**KIRKLEES METROPOLITAN COUNCIL
INVESTMENT & REGENERATION SERVICE**

DELEGATED DECISION TO DETERMINE PLANNING APPLICATIONS

Reference No:	2025/62/93371/E
Site Address:	5, Dearnfield, Upper Cumberworth, Huddersfield, HD8 8NX
Description:	Erection of two storey side extension to west elevation, including single storey rear extension, two storey side extension to east elevation to replace existing single storey garage and associated alterations
Recommending Officer:	Jennifer Booth

DECISION - REFUSED

title General arrangement as proposed
number 25073D-03-P02
scale 1:50, 1:100, 1:200
size A1

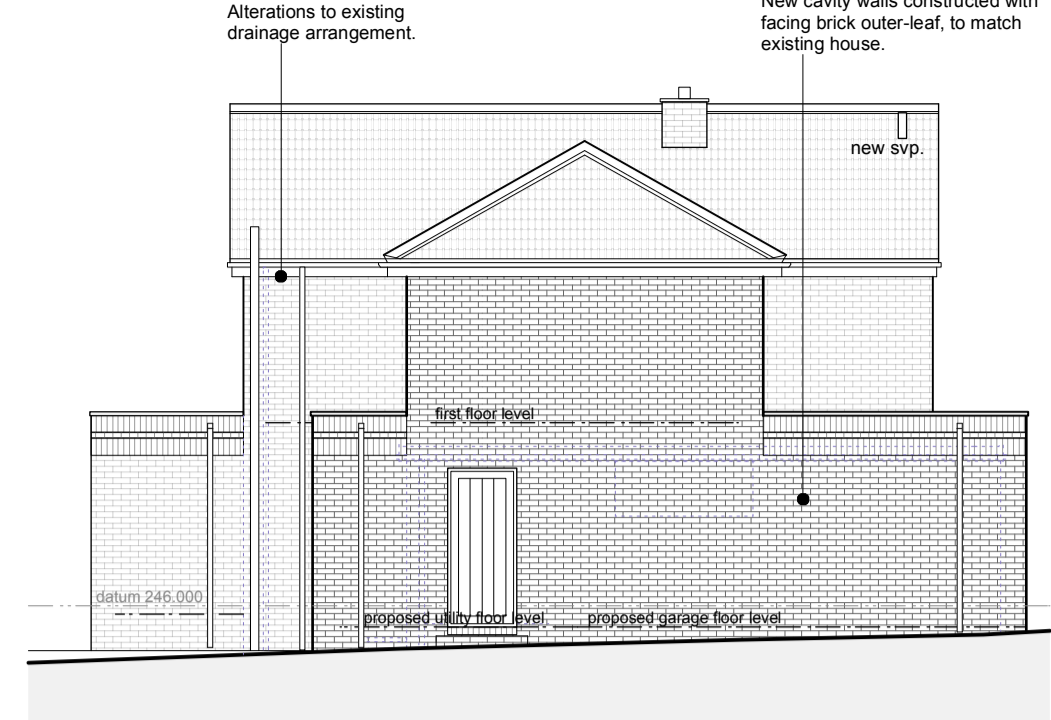
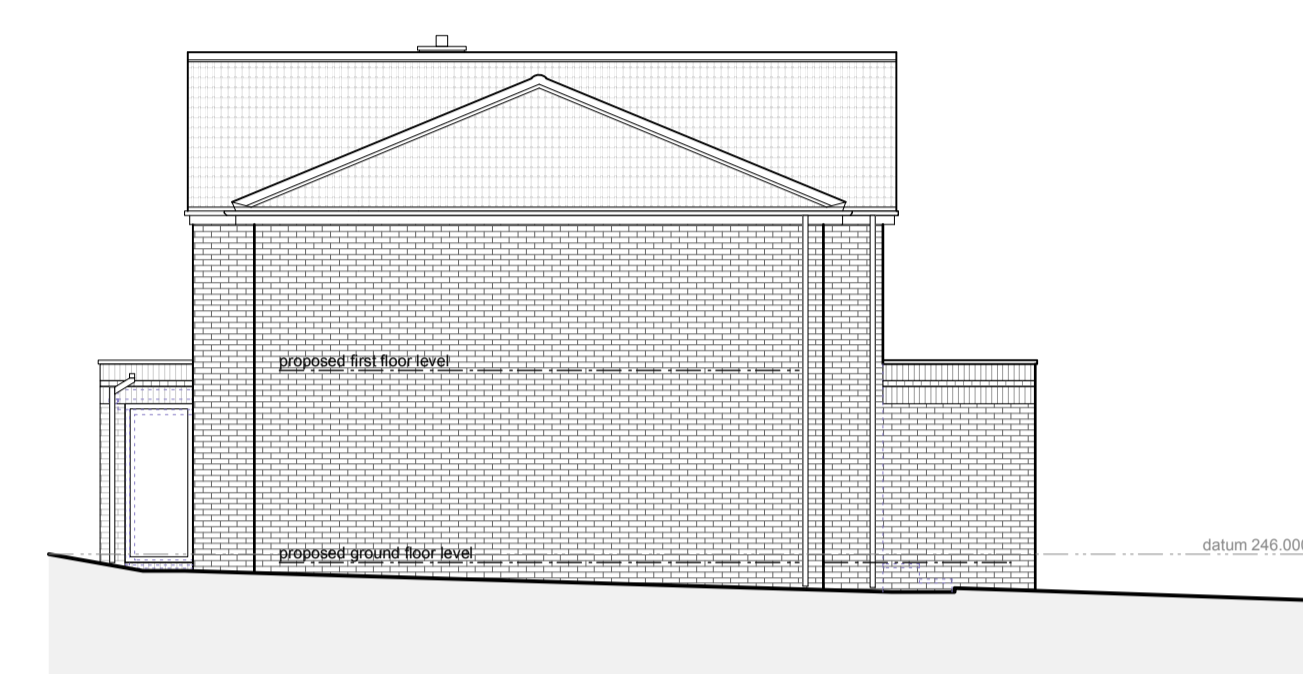
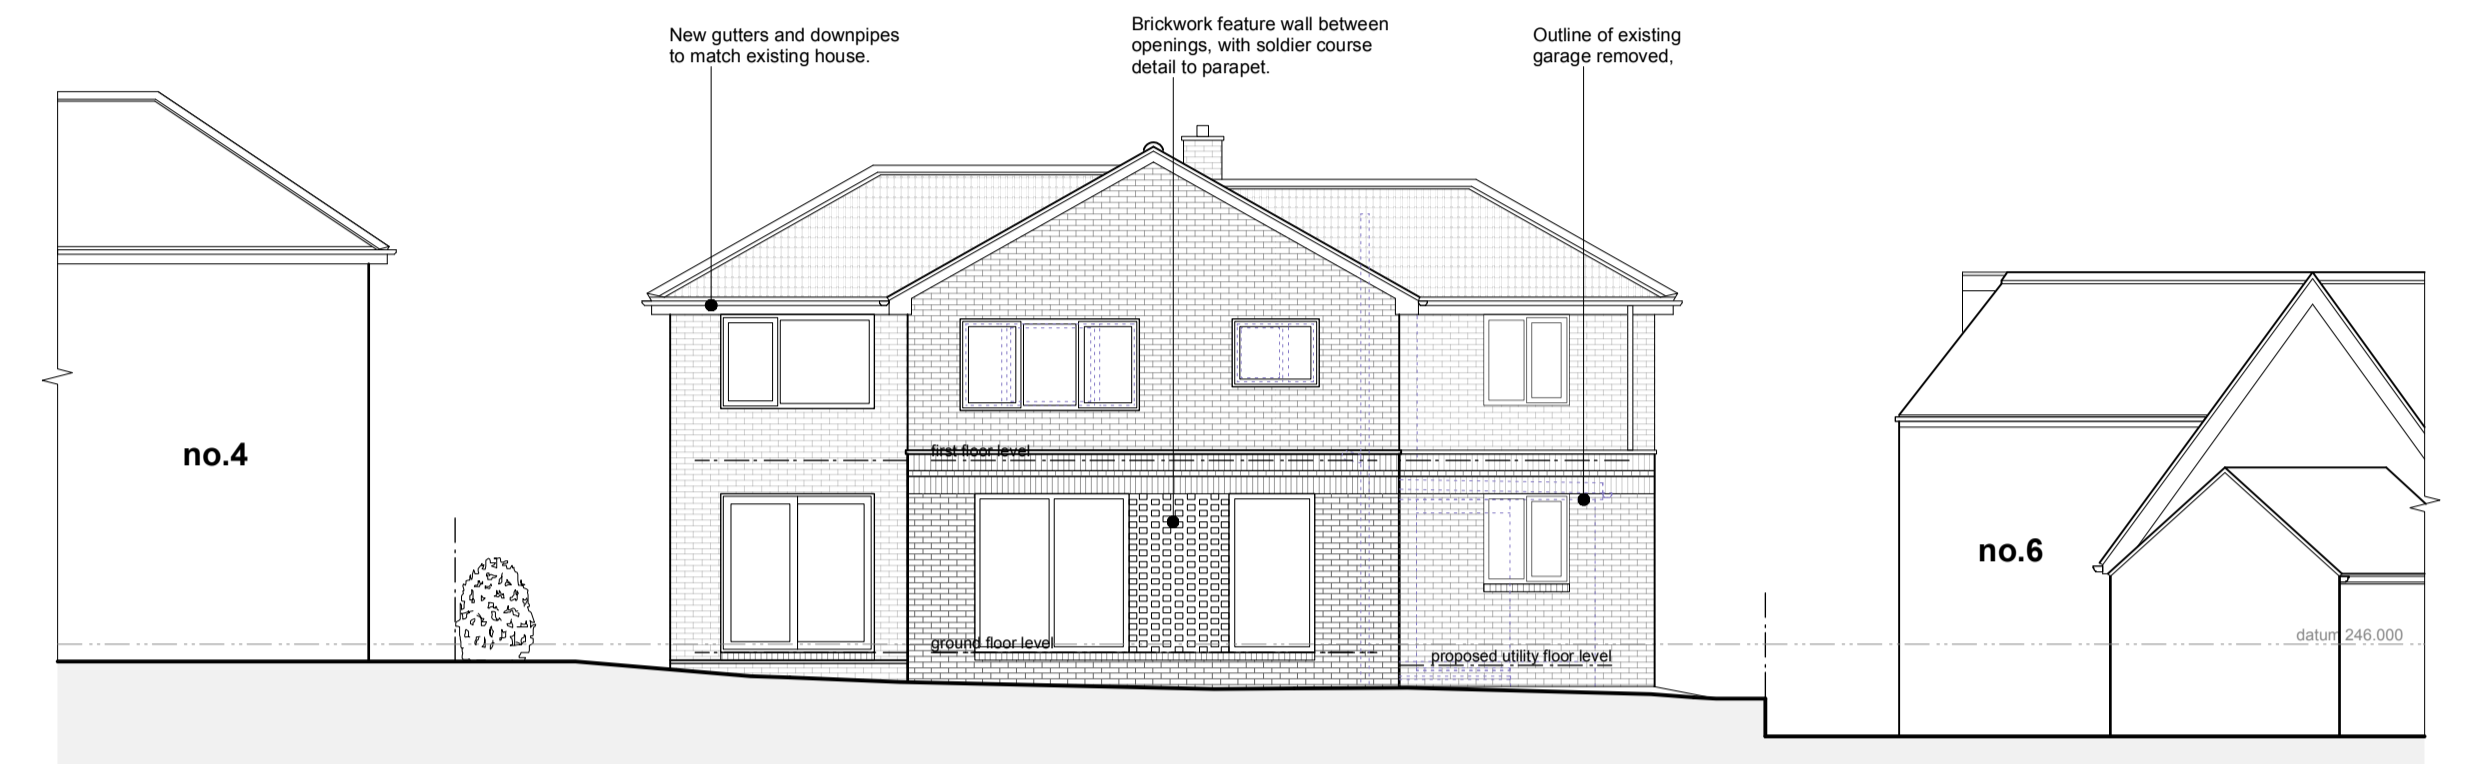
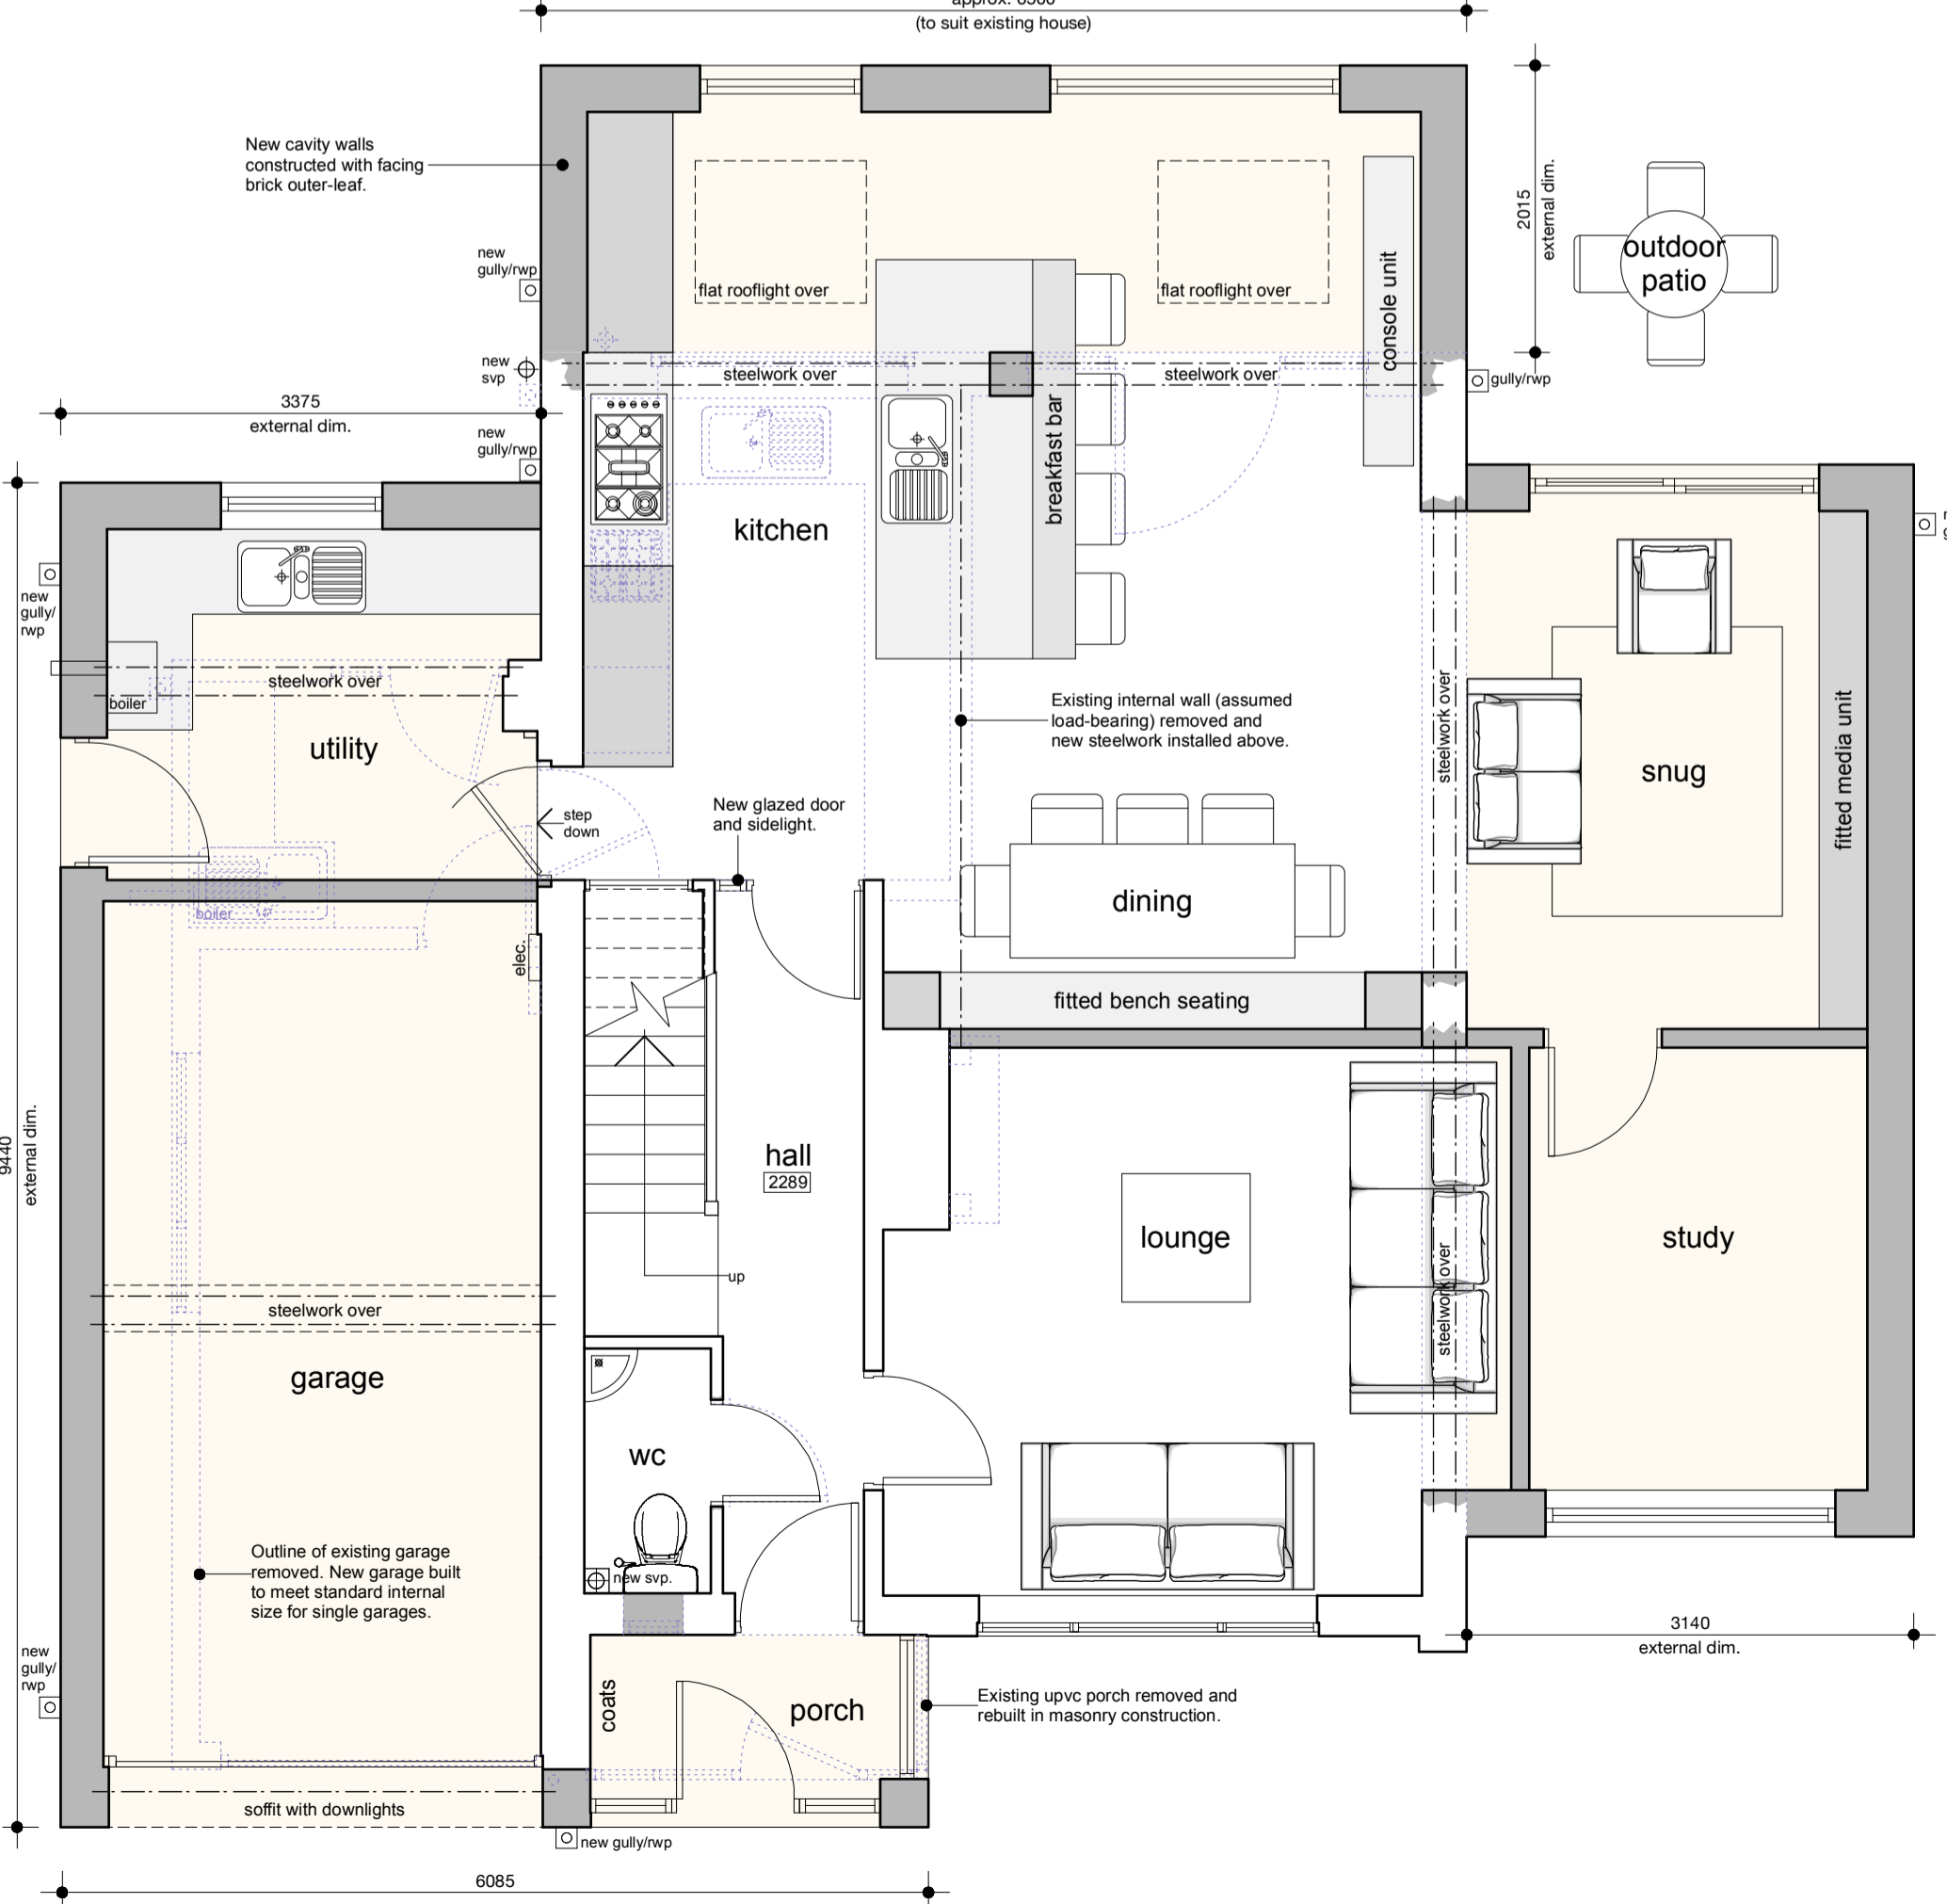
The current application demonstrates notable improvements from previous proposals, including increased front and rear setbacks, reduced ridge heights, and matching roof forms. These changes aim to address concerns regarding subservience and architectural coherence, with the applicant emphasizing compliance with the Kirklees House Extensions and Alterations SPD. However, the proposed extensions are still considered disproportionate to the host dwelling and fail to achieve a fully subordinate appearance. The scale and massing of the development remain excessive, and the design does not sufficiently overcome the previous reasons for refusal.

The applicant has argued that the cul-de-sac no longer retains a coherent architectural style due to significant modifications to neighbouring properties. While it is acknowledged that some properties have undergone alterations, the proposed dual aspect extensions to both sides of the dwelling, combined with its prominent siting, result in a bulky and incongruous development. The extensions are larger and more dominant than any other property in the street, disrupting the character and appearance of the area and creating an unbalanced composition.

Officers conclude that the application does not adequately address the previous reasons for refusal, as the extensions continue to appear overly dominant and inconsistent with the character of the area. Consequently, the proposal fails to comply with Policy LP24 of the Kirklees Local Plan (a) in terms of the form, scale and layout and (c) as the extension would form a

The proposed extensions and alterations, due to the design and scale would not form subservient additions to the property and would result in a contrived and unsympathetic appearance which would be harmful to the character of the host property and the surrounding area. To permit the proposals would be contrary to Policy LP24 of the Kirklees Local Plan, KDP1 & KDP2 of the House Extensions & Alterations SPD and advice within Chapter 12 of the National Planning Policy Framework.
